PLAN REVIEW SHEET

Date:	07/21/2008	Staff Contact:	David McDonald
Petitioner:	Fairview Plaza Associates Limited Partnership	Telephone:	704-336-6900
Petition:	2008-127	Fax:	704-432-1277
Location:	Approx. 1.89 acres on south side of Fairview Rd btwn Park South Drive and J.A. Jones Drive	Email:	dmcDonald@ci.charlotte.nc.us
Existing Zoning:	MUDD(CD)	Attachments:	WP_Only_w_PS_60.01A.pdf
Requested Zoning:	MUDD-O Amend CD rezoning to recognize site development in phases and to accommodate installation and use of temporary parking lot

FIRST SUBMITTAL

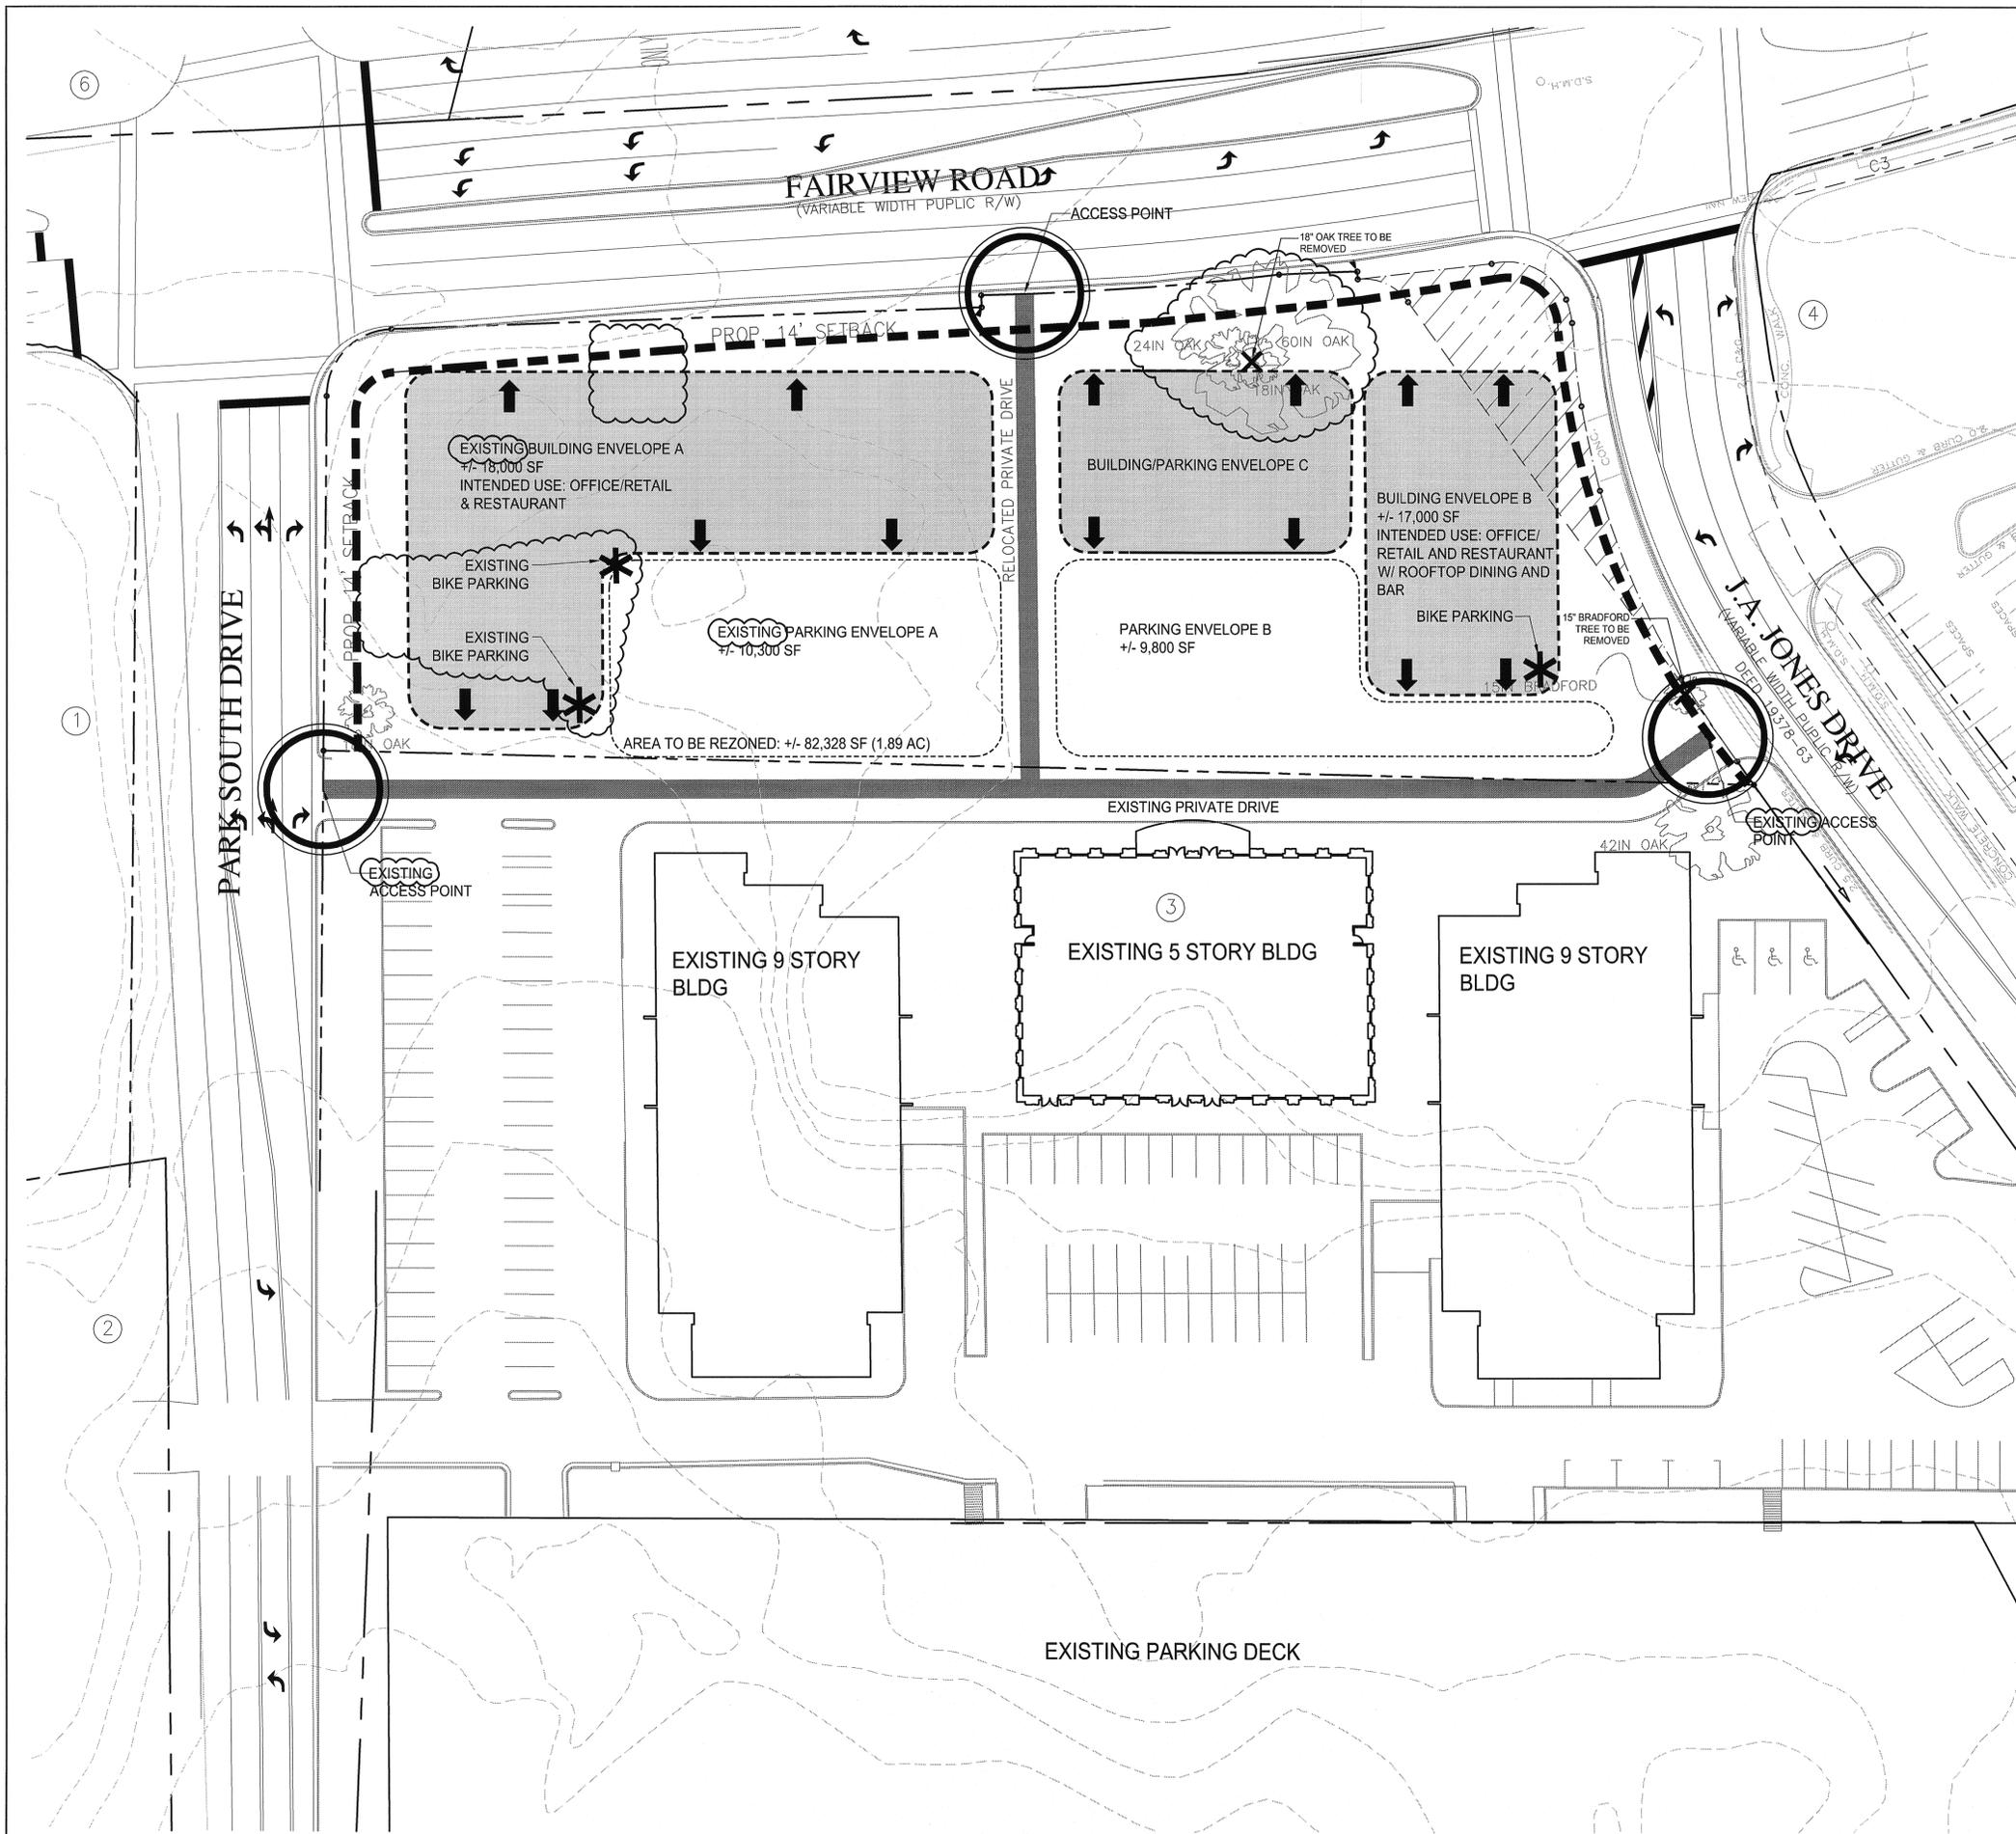
- 1) **The petitioner’s site is currently served by CATS Routes: 19 Park Road, 57 Archdale/SouthPark, and 60 Tyvola/SouthPark.**
- 2) **CATS recognizes CDOT’s memorandum comment requesting the petitioner to replace the back-of-curb sidewalks along Fairview Road and J.A. Jones Drive with new 6’ sidewalks and 8’ planting strips.**
- 3) **Thus, CATS requests the petitioner to construct a concrete waiting pad on Fairview Road at the location of the existing bus stop (CATS Stop ID #10470), constructed to CATS Development Standards 60.01 A (see attached).**
A waiting pad is the connecting piece of concrete which is installed from the back of curb through the planting strip to the sidewalk. The waiting pad provides an ADA accessible boarding and alighting location for CATS’ passengers.

Please designate such in the site plan and/or accompanying notes. Please contact Leonard Ganther (CATS Operations) @ 704.432.1283 prior to demolition or construction to coordinate the final location of the waiting pad.
